From: [REDACTED]
Subject: Norfolk Vanguard Project EN010079.
Date: 15 January 2019 17:27:51

Indicative Onshore Project Substation
Mitigation Planting - Norfolk Vanguard

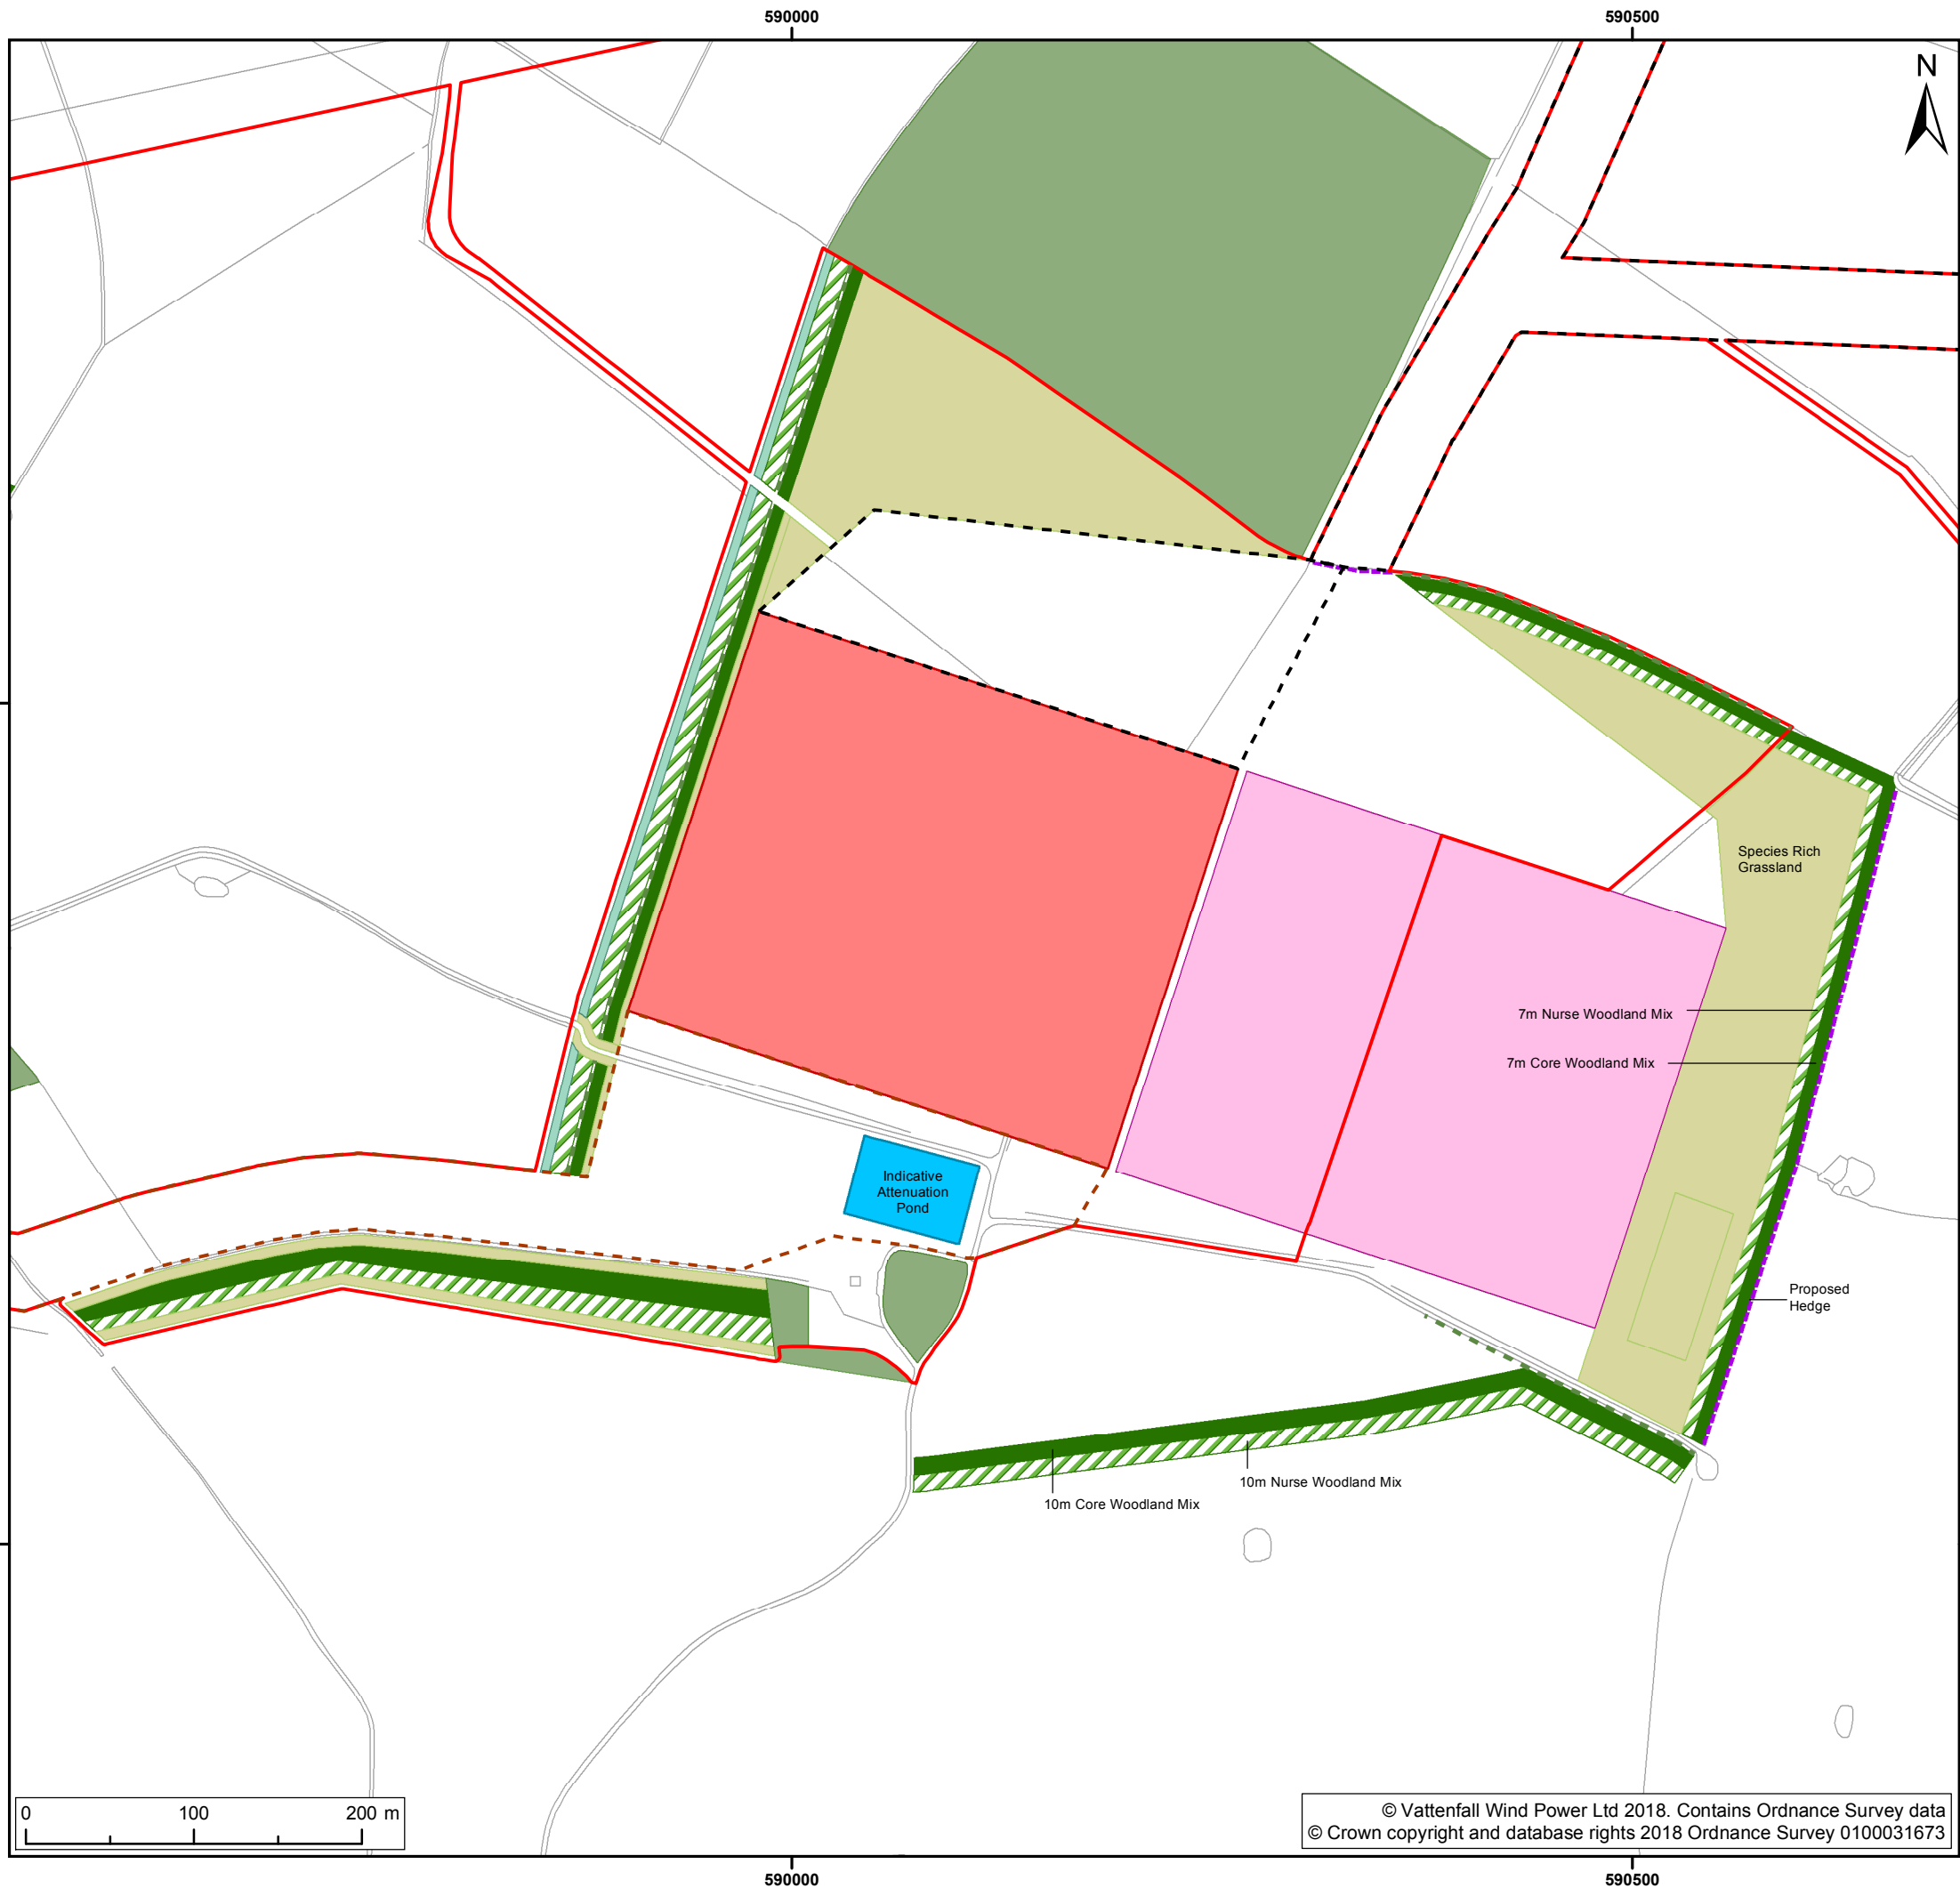
The visual mitigation to the SE of the national grid connection point and the south of the Vanguard substation seems inadequate. They intend to use native trees, and no earth bunds ("as they would look out of place"). With converter halls 110m long, 20m high and lighting conductors 25m high, this dose not add up. Teared planting has been mentioned close to our property, to gain a perspective advantage, and I have a suspicion Vattenfall expects it to be acceptable to plant on our land. As we have only 80 acres to farm. I do not think it unreasonable to say, every meter is needed, and therefor unwilling to use land for this purpose. The

situation then arises, that if we refuse any offered tree planting on our land, would that let Vattenfall out of their mitigating obligations, or would they sort to find land between them and us? .
